**ADC Planning Consultation
Conservation/Design Officer Response**

Application Number	BE/14/17 & BE/15/17
Address	Land to the rear of 95-99 North Bersted Street, Bersted
Description	New double garage affecting the setting of designated heritage assets
Case Officer	Simon Davis
Date	20 April 2017

Client	Project	Title	Status	Drawn by	Reviewed by
C. TOMKINS	REAR OF 99 NORTH BERTSD STREET	PROPOSED GARAGE	PLANNING	SJ	SJ
			DATE	SCALE	DRAWING NUMBER
			26.01.17	1:100@A3	8

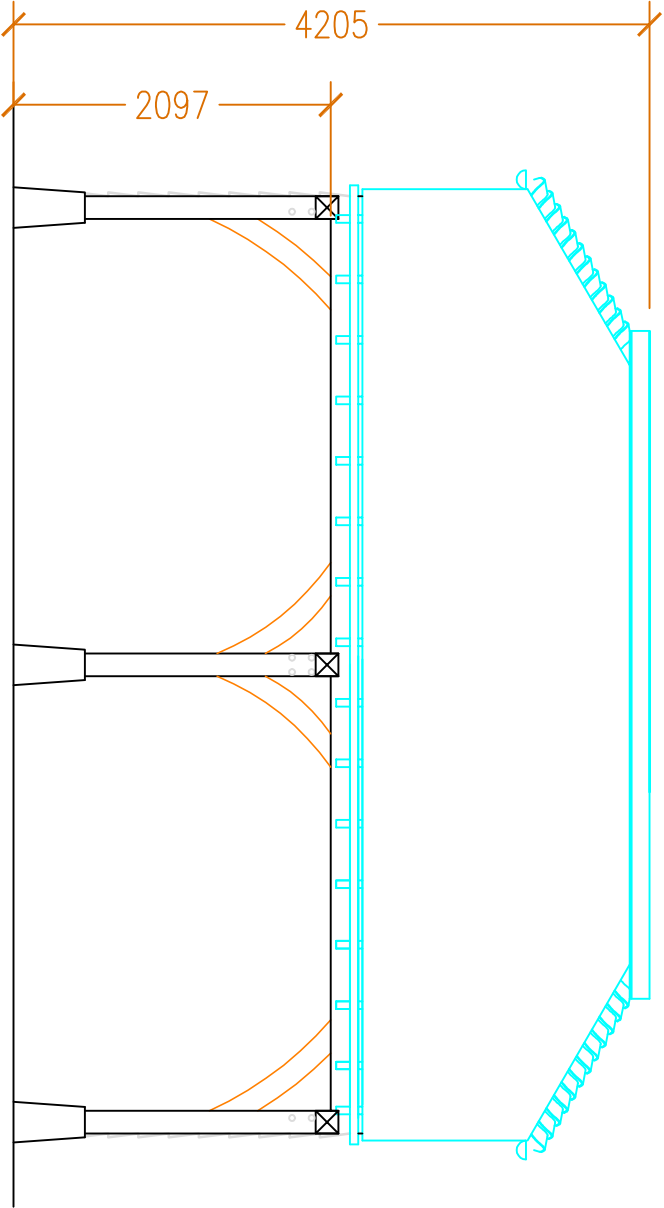
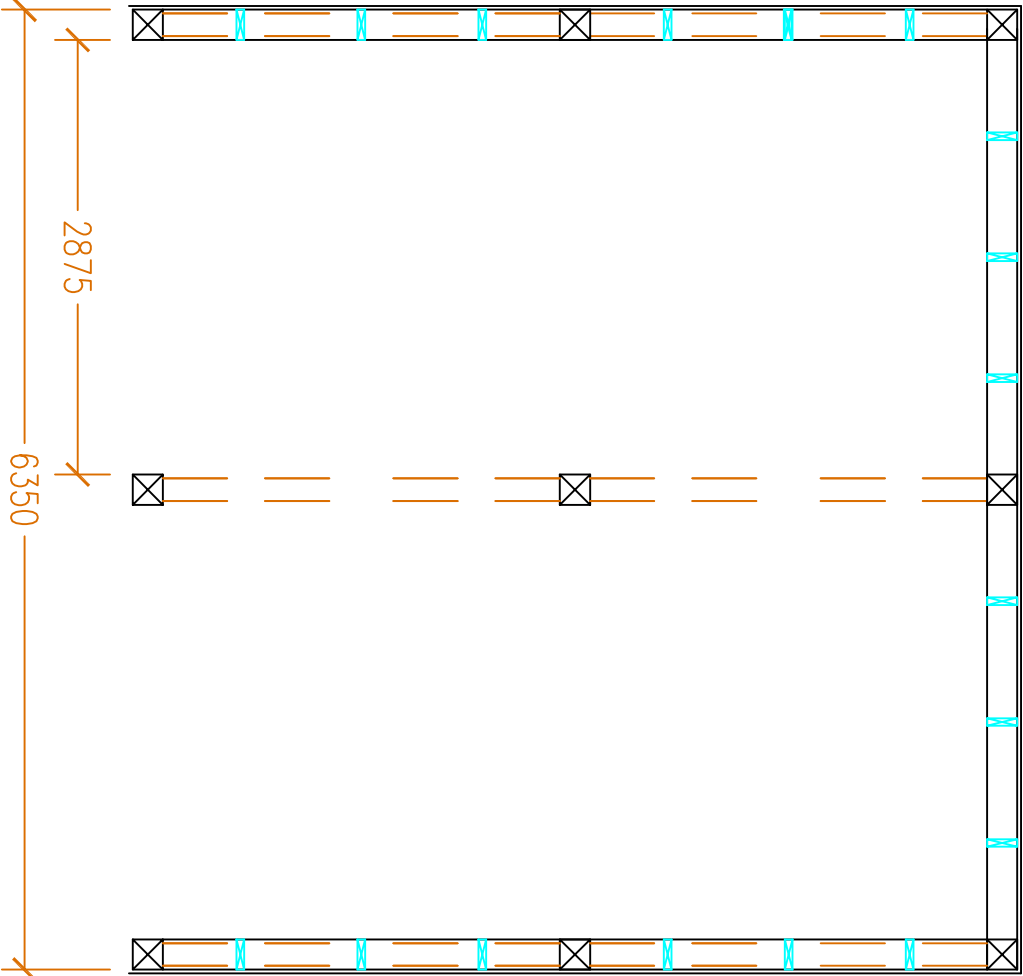
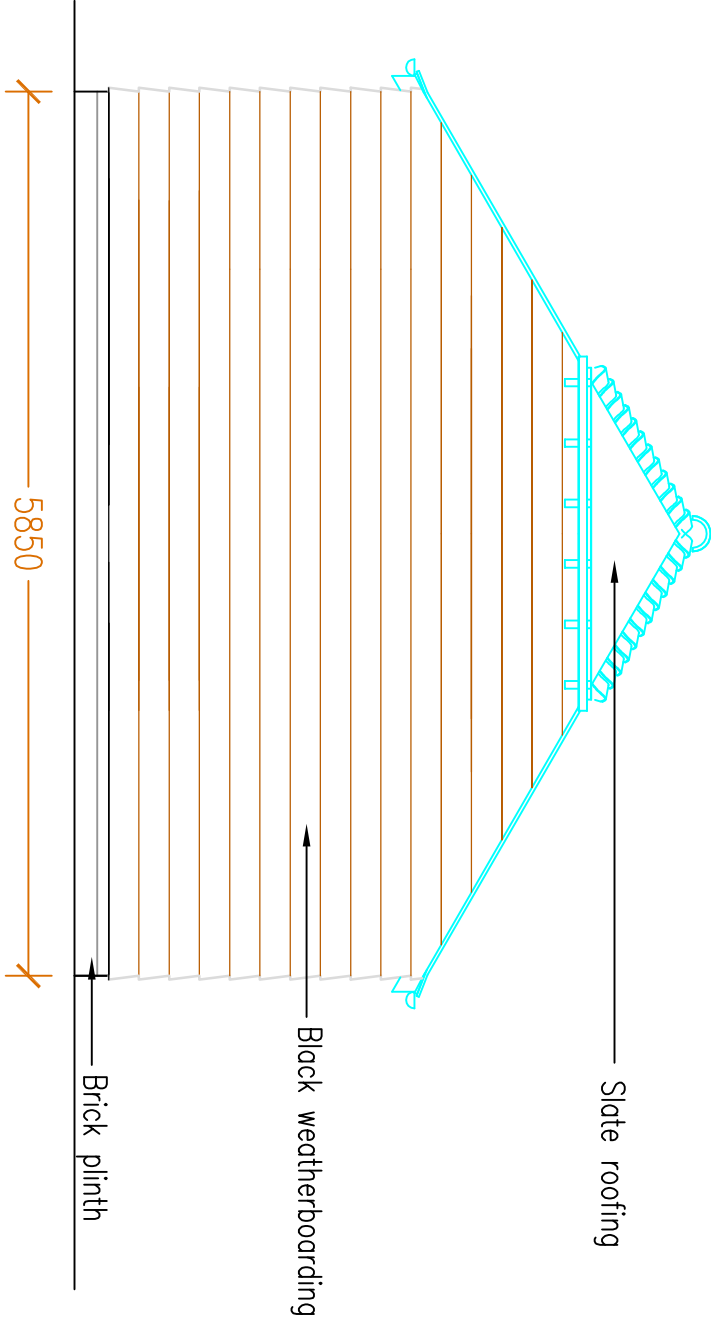
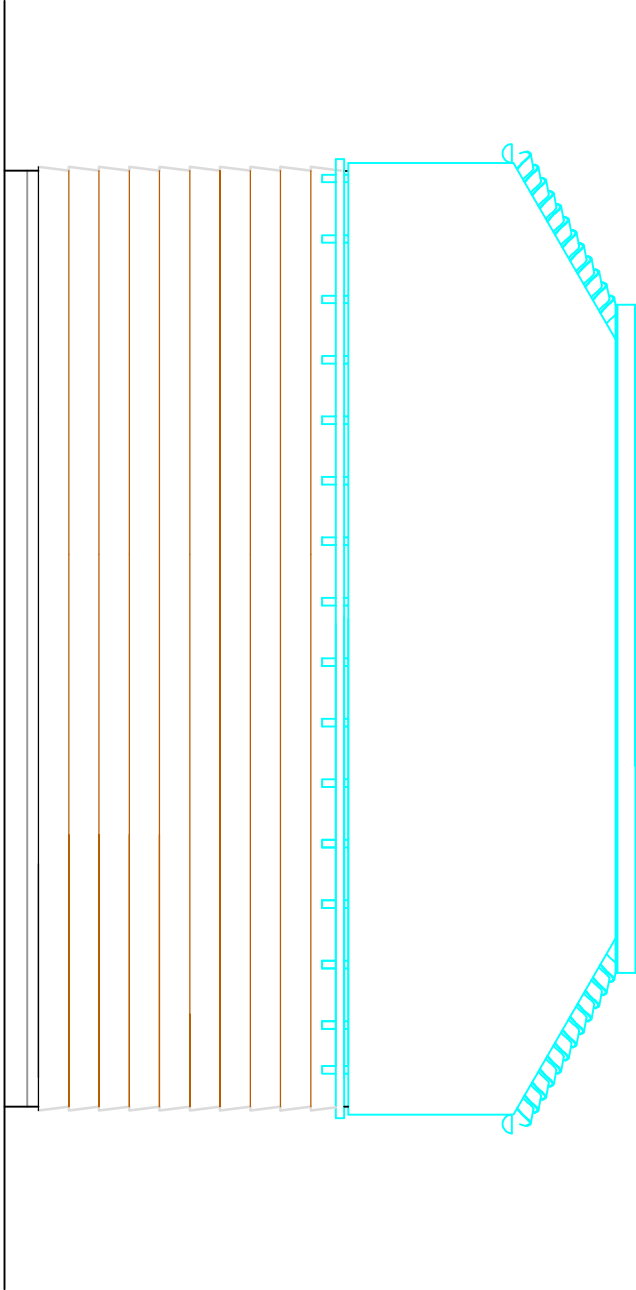
The proposed garage is associated with a recently permitted dwelling located just outside the northern boundary of the Bersted conservation area and some distance to the north of two, grade II listed buildings. While the additional new development may have little impact on the settings of the listed buildings, it exacerbates the intrusive presence of the adjacent dwelling, which was resisted in terms of the Council's conservation Policies.

Randomly located, isolated buildings of this nature are alien to the traditional frontage pattern of development and they intrude into long, countryside views. The proposed garage contributes to a gradual accretion of 'backland' buildings outside the settlement boundaries, and the cumulative effects erode locally distinctive qualities of the designated area and diminish its significance.

The proposal is thus contrary to Para. 132 of the NPPF, which requires great weight to be given to the conservation of designated heritage assets and notes that significance can be harmed or lost through inappropriate development within their settings. Refusal is therefore recommended in terms of Local Plan 2003 Policy Area 2 and Local Plan 2014 Policy HER DM3.
